Response to Report by Galway County Council

Cooloo Wind Farm (ACP
Ref. 323761)

MKO has prepared a response, on behalf of Neoen Renewables Ireland Ltd. (the Applicant), to the report received from Galway County Council (GCC), as requested by An Coimisiún Pleanála (the Commission, ACP) on 13th January 2026 in relation to the Strategic Infrastructure Development (SID) planning application before them for consideration (ACP Ref: 323761).

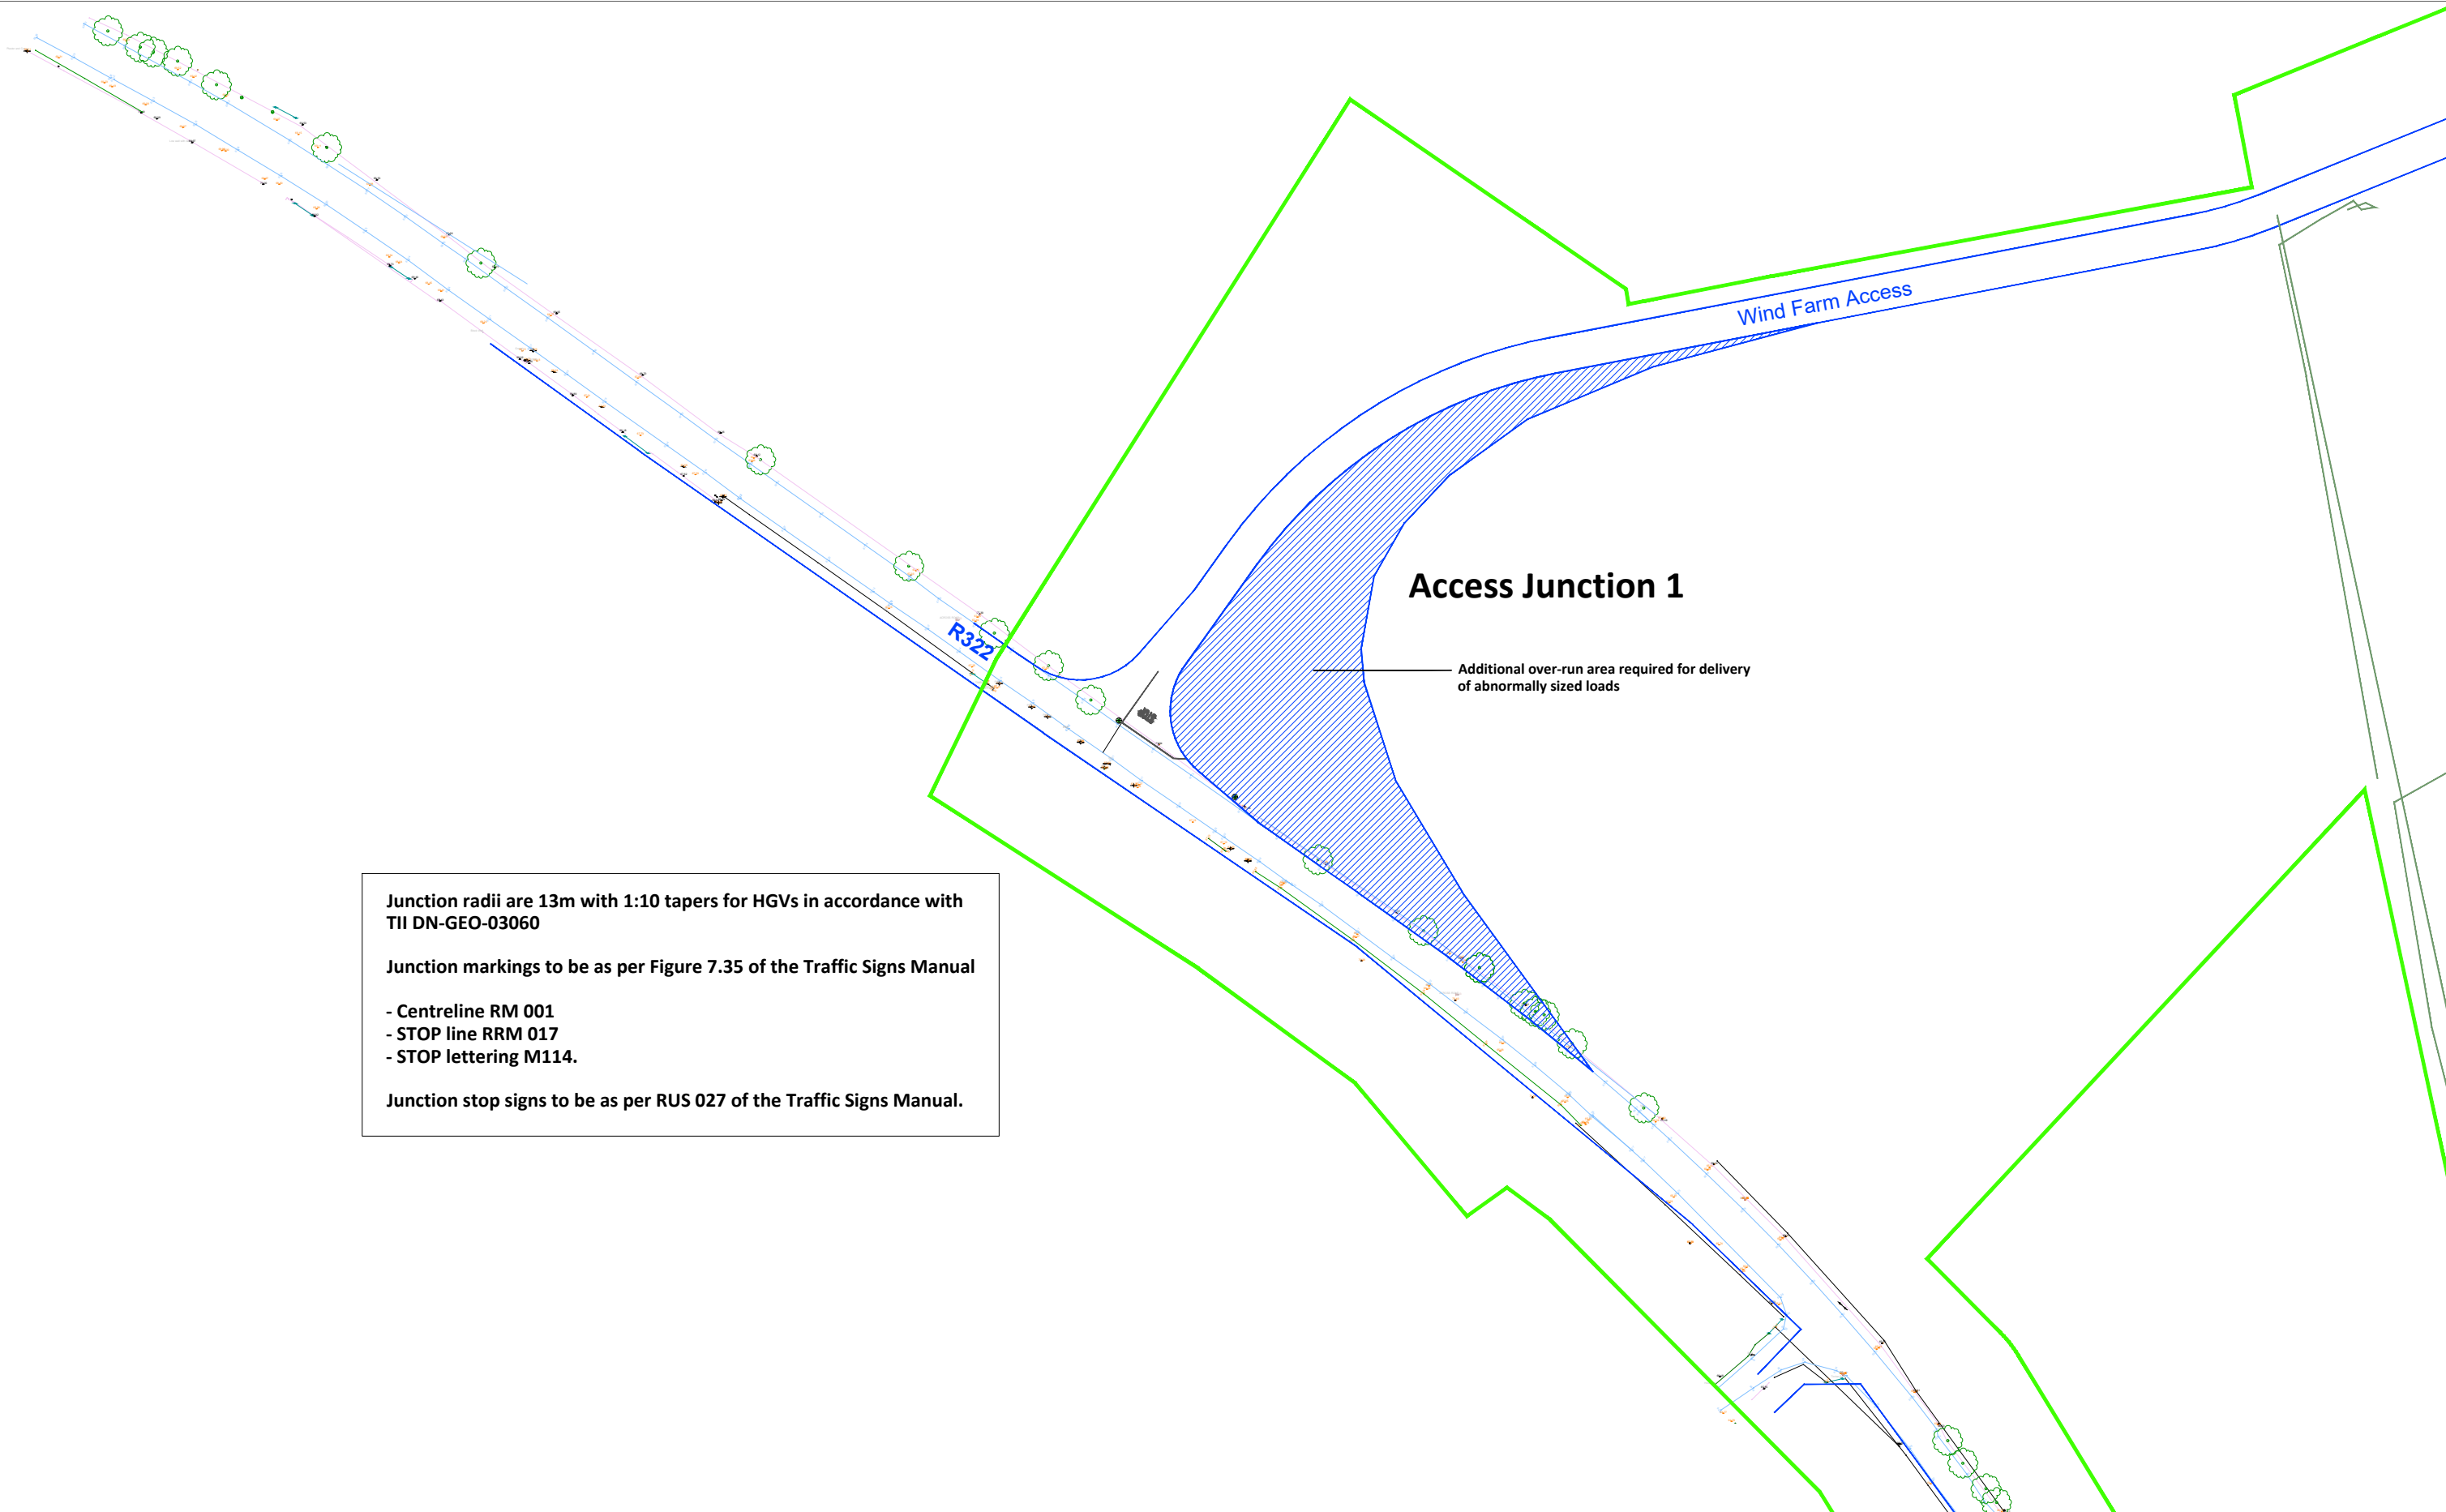
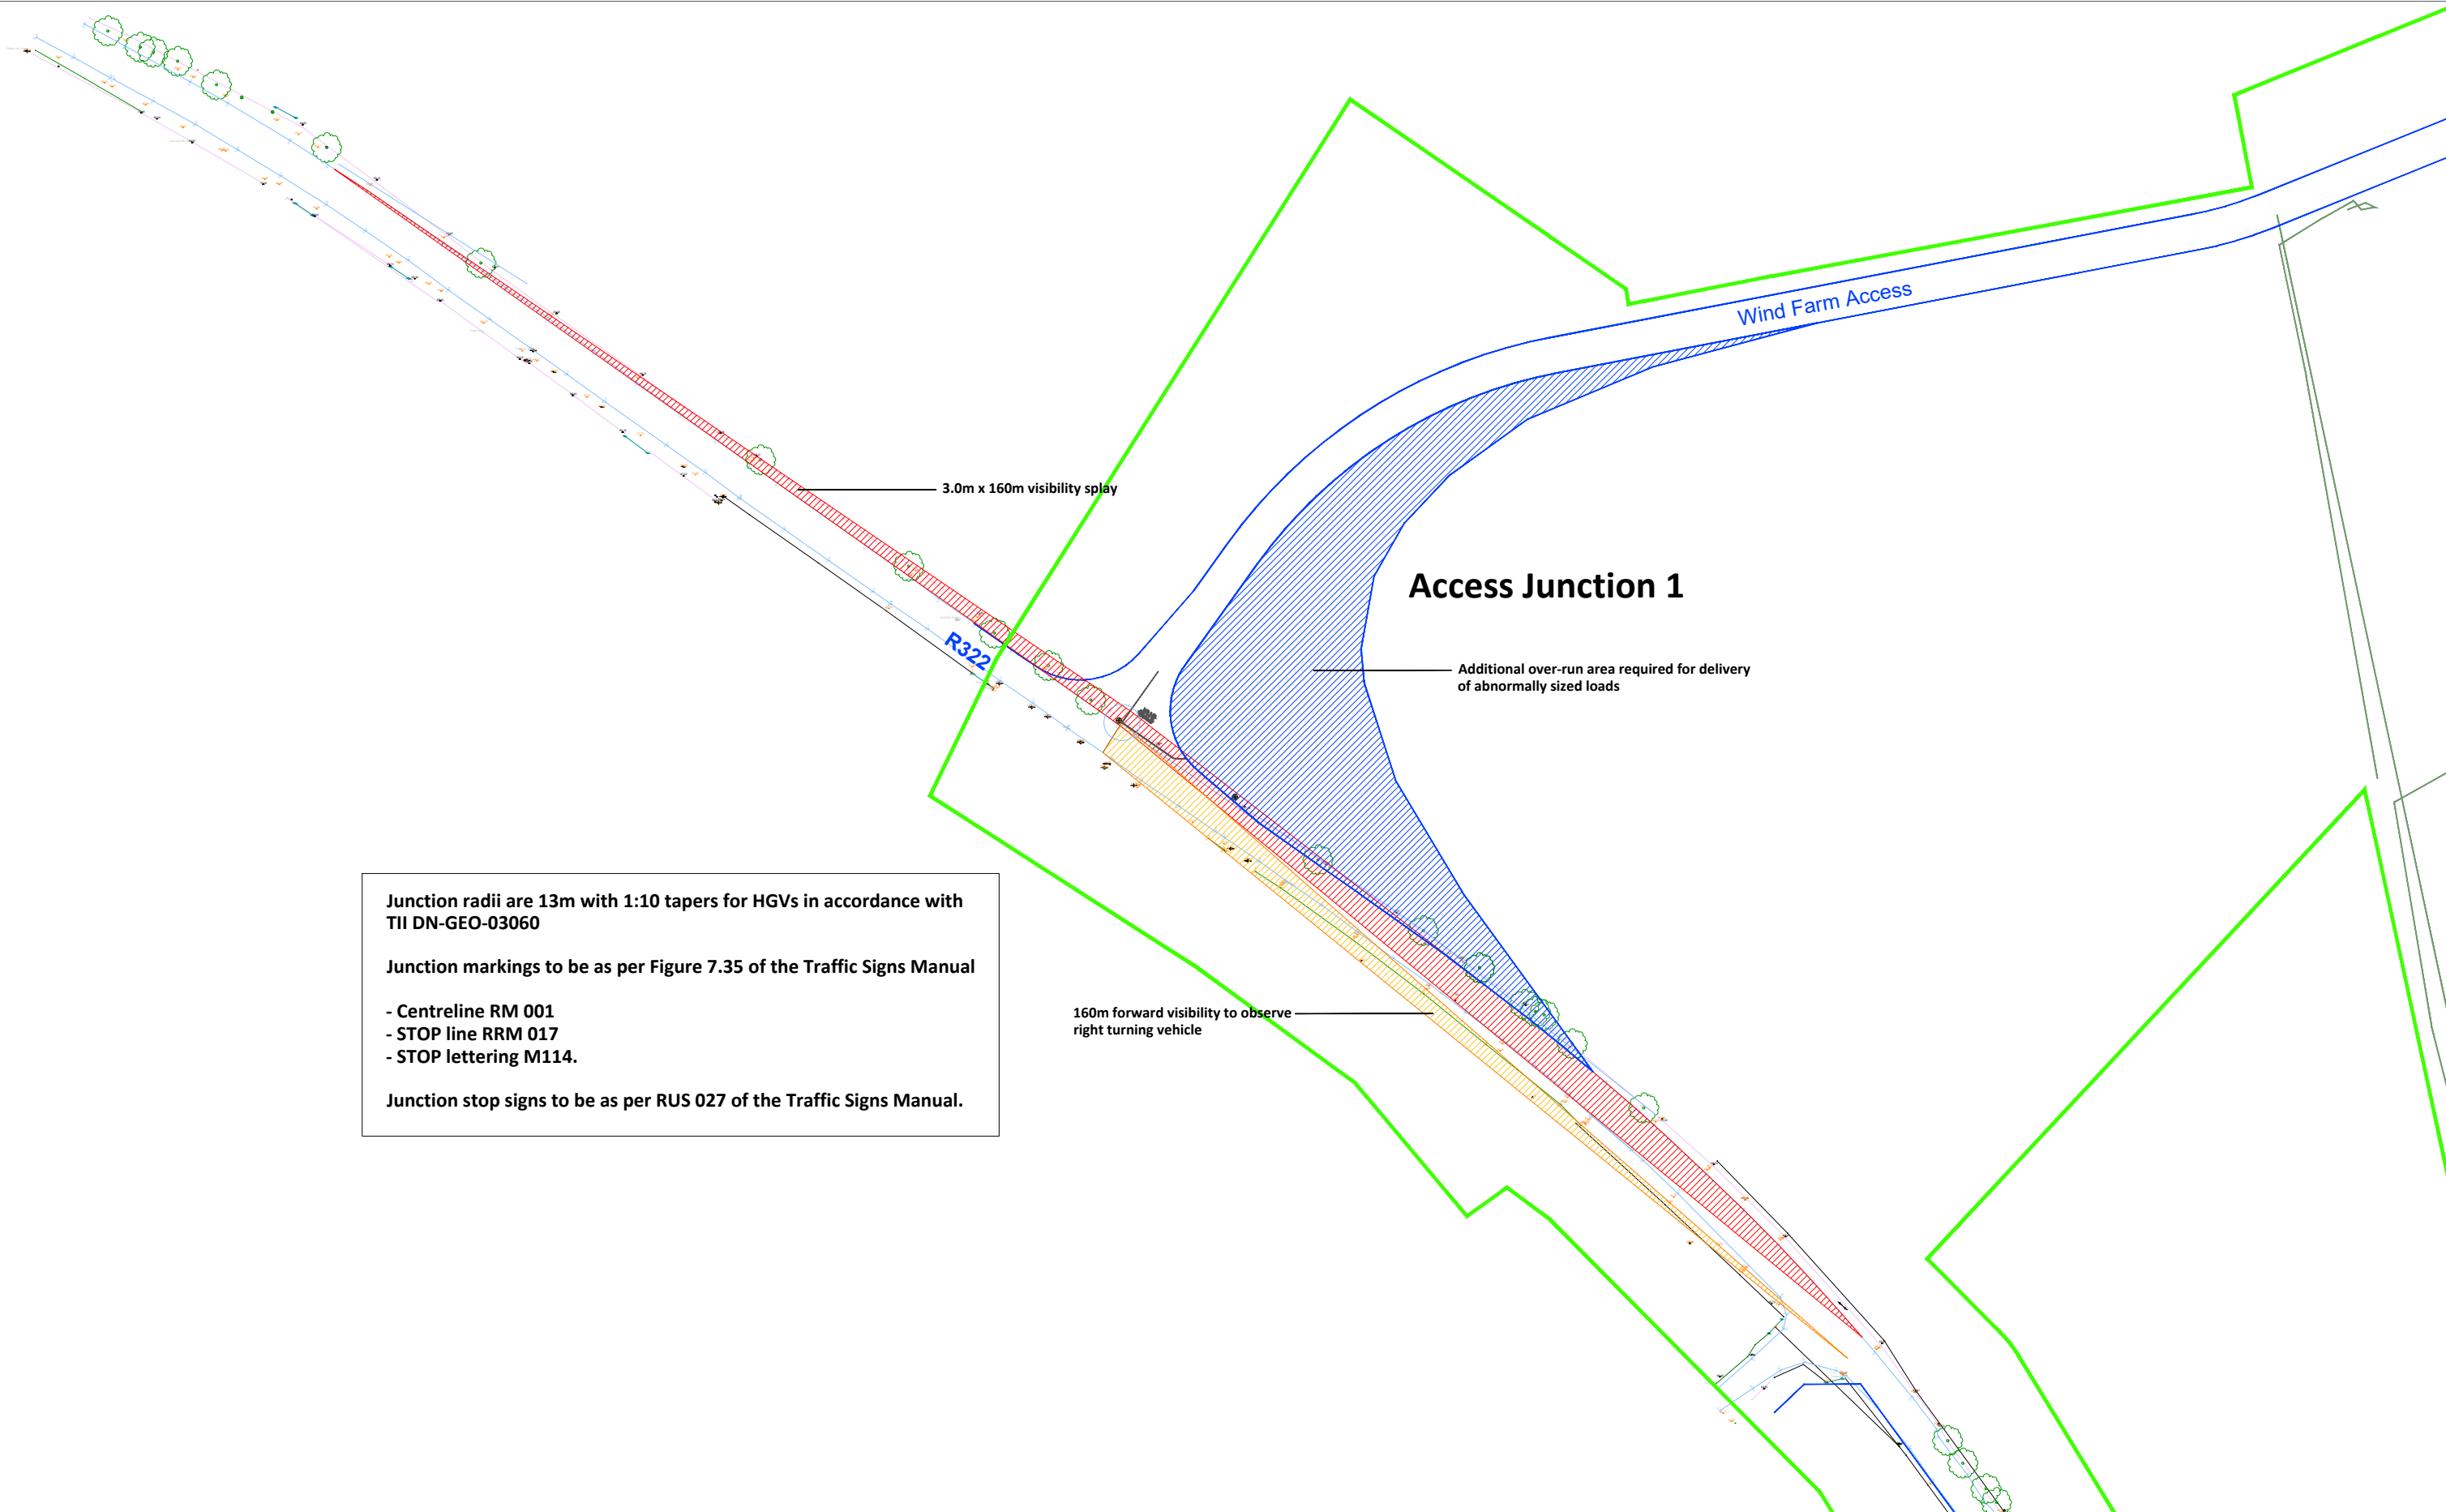
- ii. *The required Visibility splays in relation to compliance to forward and stopping sight distance triangles where the Regional R332 road speed limit resides whilst owing to the sub optimum horizontal and vertical alignment & profile of the public road as denoted by continuous white line at midpoint of road and where the subject site proposes to introduce new site entrance/access onto regional route network is considered to be restricted. The vertical envelope of visibility (i.e. intervisibility) has not being demonstrated in accordance with TII standards, in particular the provisions of visibility requirements as stated within DN-GEO-03031 Rural Road Link Design, May 2023- Section 2 Sight Distance, Figure 2.1 would render the road network, or any part of it, unsuitable to carry the additional road traffic including additional generated turning movements likely to result from the proposed development. It is considered that if permitted as proposed that the development would endanger public safety by reason of traffic hazard, obstruction of road users or otherwise, contrary to policy objectives NNR2, and DM Standards 28, and DM standard 33a of the Galway County Development Plan 2022-2028.*

It is noted that the required visibility splays for an 80 kph speed limit, 160m along the nearside carriageway edge taken from a setback of 3.0m, are available along the R332 construction phase site entrance to the west and east and the full forward 160m forward visibility for traffic approaching from the east to observe a vehicle waiting to turn right into the Proposed Wind Farm site is partially constrained by existing shrubs and bushes. As a result, a detailed Traffic Management Plan (TMP) incorporating all the mitigation measures is included as Appendix 15-2 of this EIAR, which will be finalised and confirmatory detailed provisions in respect of traffic management agreed with the Road Section of GCC prior to construction and contact will be maintained with the Road and Traffic Section throughout the construction phase. Mitigation measures outlined in Appendix 15-2 include the following:

- The bush / shrubs on the south side of the R332 are trimmed in order to maximise forward visibility. It is estimated that a forward visibility of approximately 140m may be achieved by trimming the roadside bushes alone.

- An application to Galway County Council for a temporary reduction of the speed limit on this section of the R328 to 60 km/h during the 18 month construction phase of the Proposed Project,

- The introduction of Traffic signs in accordance with the *“Traffic Signs Manual, Section 8 – Temporary Traffic Measures and Signs for Road Works”* (DoT now DoTT&S) and *“Guidance for the Control and Management of Traffic at Roadworks”* (DoTT&S). The proposed traffic management measures will be submitted to Galway County Council’s Roads section for agreement prior to the construction phase.

- The provision of a flagman at all times that the proposed access junction is in use during the construction phase.
- The closure of the site access by means of temporary fencing and gates during periods when the access is not in use, including evenings during the construction phase.

- The permanent closure of the site access junction on completion of the construction phase. This junction will only be opened for the purpose of the replacement of large component parts.
